Consultation Response from KC, Highways Development Management
2025/90026 Moor Top Farm, Moor Top Road, Kirkheaton, Huddersfield, HD5 0PJ
Prior notification for change of use from agricultural buildings to 5 dwellings
Date Responded: 12-3-2025. Responding Officer: Mark Berry. Responding Ref: 11-5NW-6.
Prior notification for change of use from agricultural buildings to 5 dwellings at Moor Top Farm, Moor Top Road, Kirkheaton, Huddersfield. The group of agricultural buildings are proposed to be converted into five single storey dwellings. One 4 bedroomed dwelling and four 3 bedroomed dwellings are proposed. The 3 bed dwellings are shown to have 2 off-street parking spaces and the 4-bed dwelling as 3 off-street parking spaces. A shared turning area is shown to be provided within the application site adjacent to the parking spaces for units 2 to 5. One additional parking space for visitors is also proposed. Information within the Class Q Compliance Statement prepared by Robert Halstead Chartered Surveyors & Town Planners regarding transport and highways impacts of the development is as follows. “The proposed dwellings would be accessed via an existing surfaced driveway from Moor Top Roa

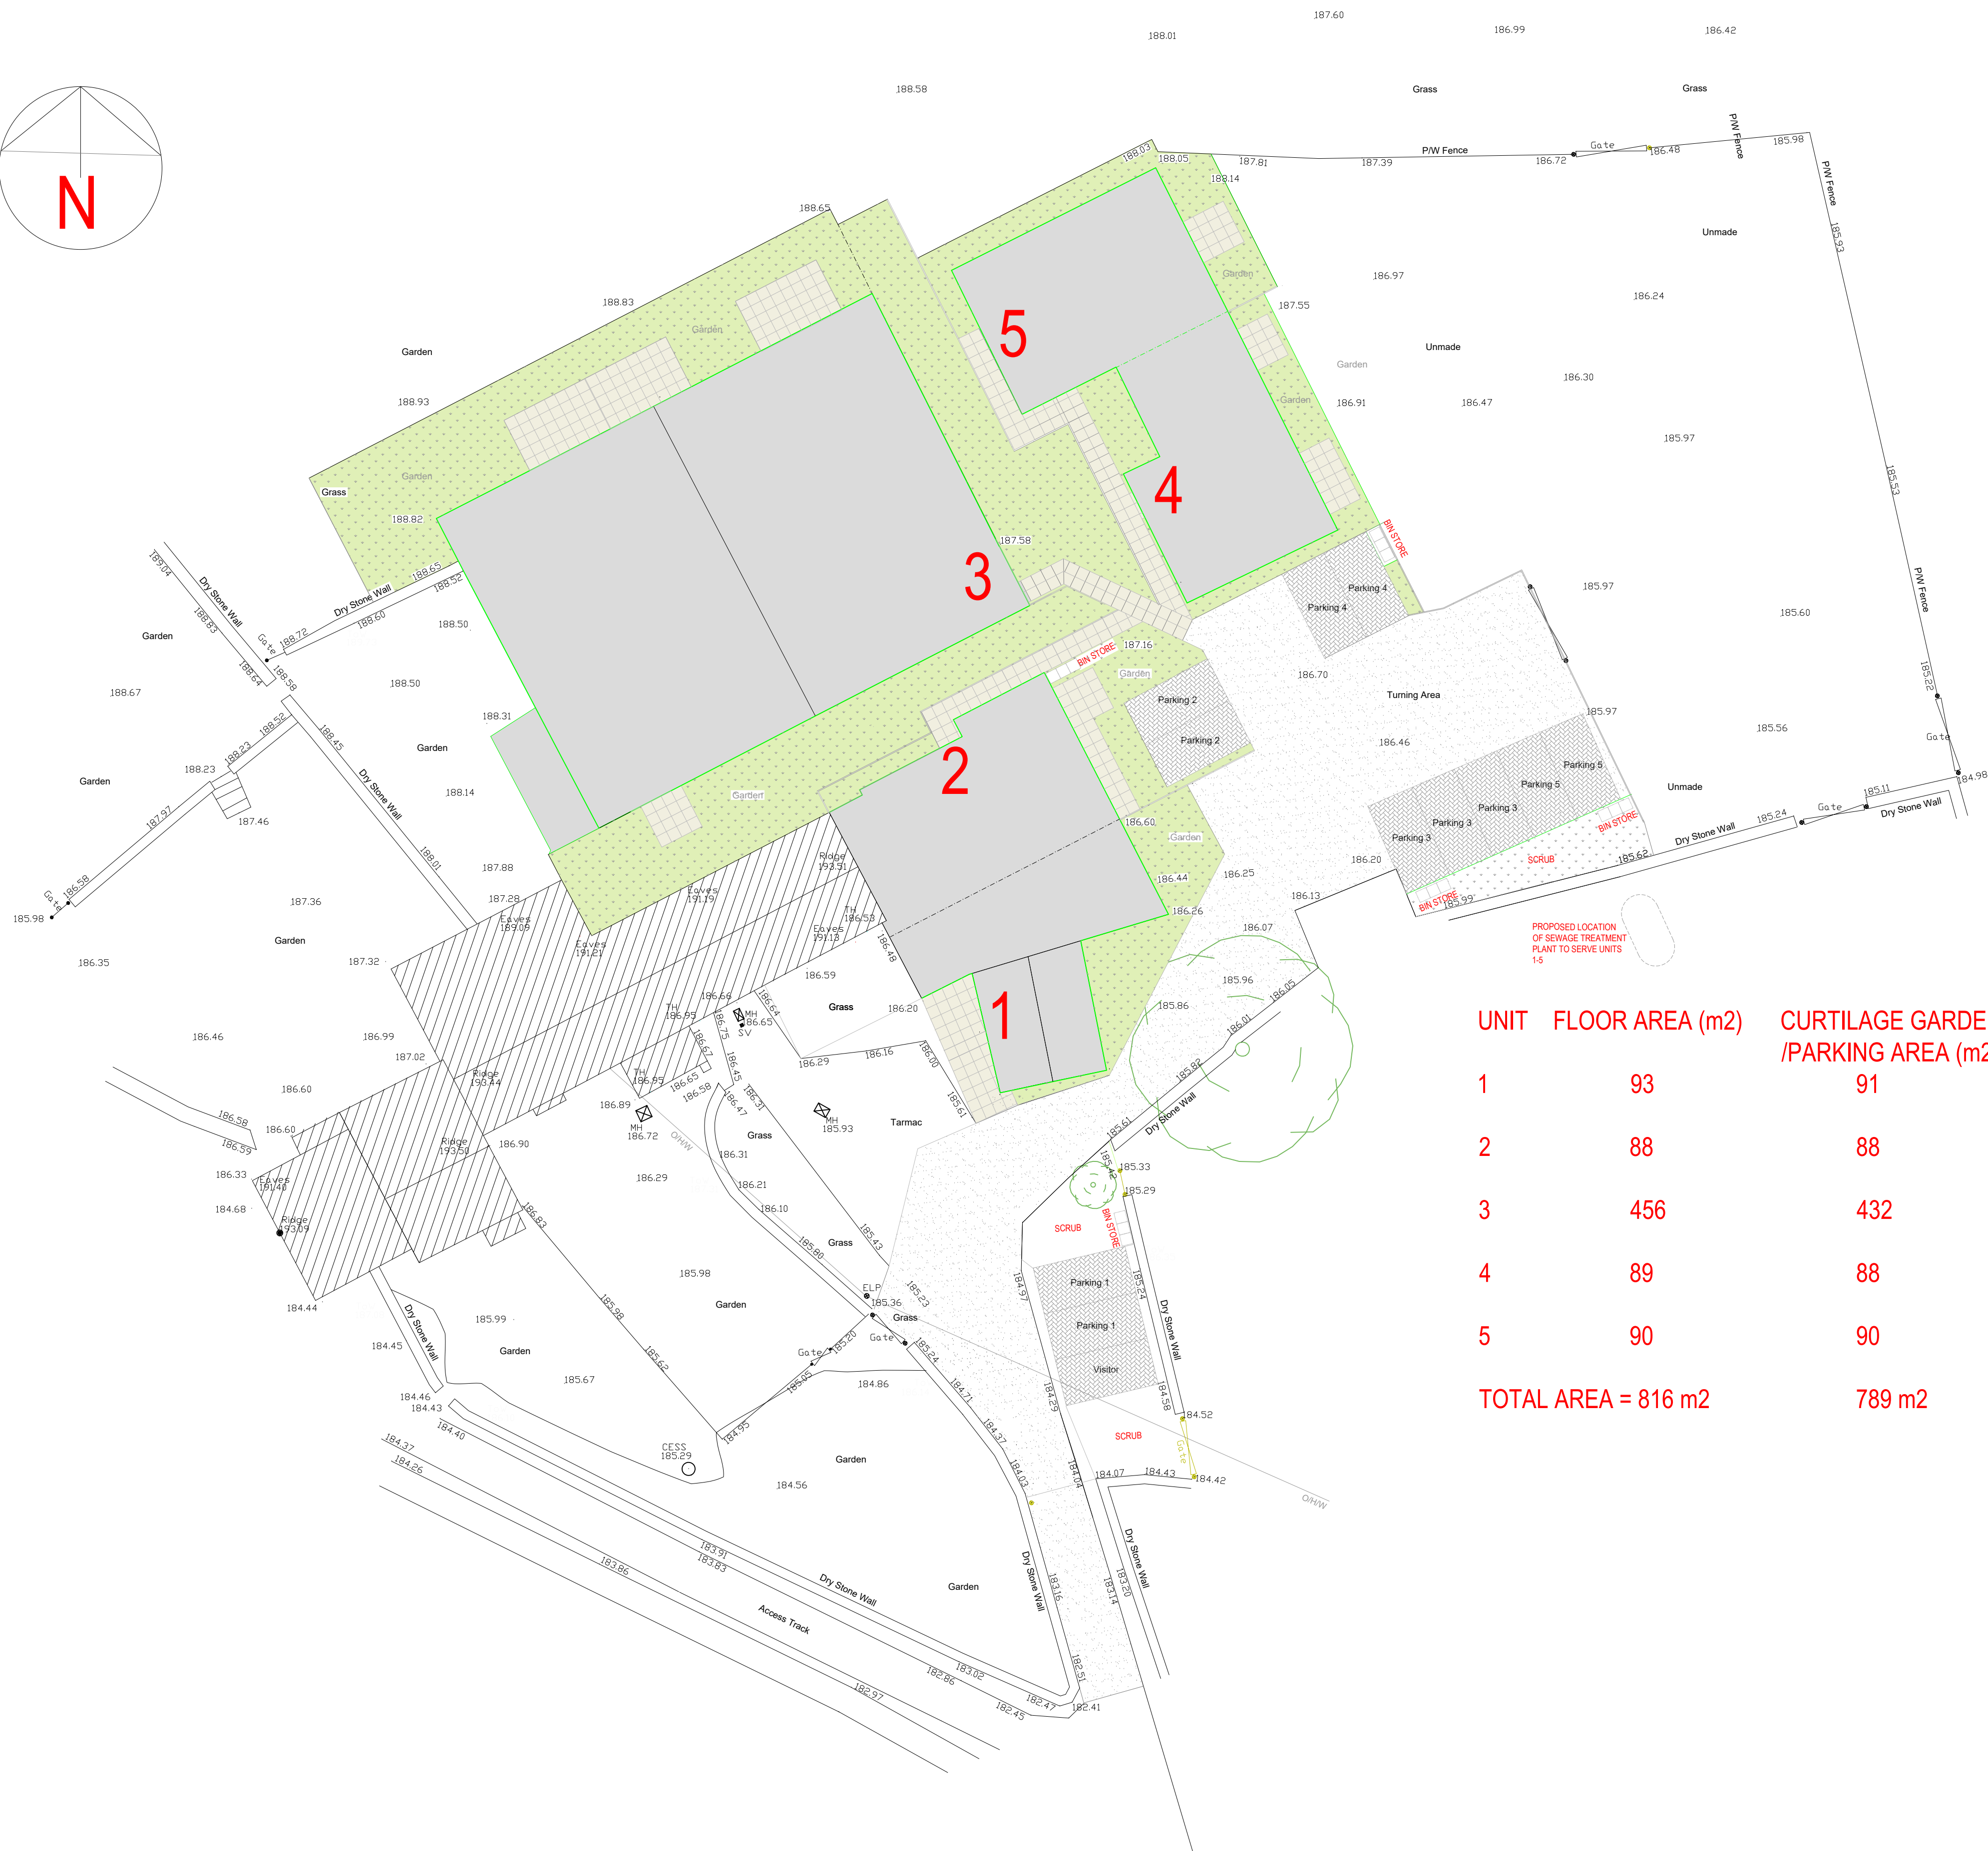
3, The width of the access at its junction with Moor Top Road should be shown to be a minimum of 4.5m to potentially allow 2 vehicles to pass at the access.
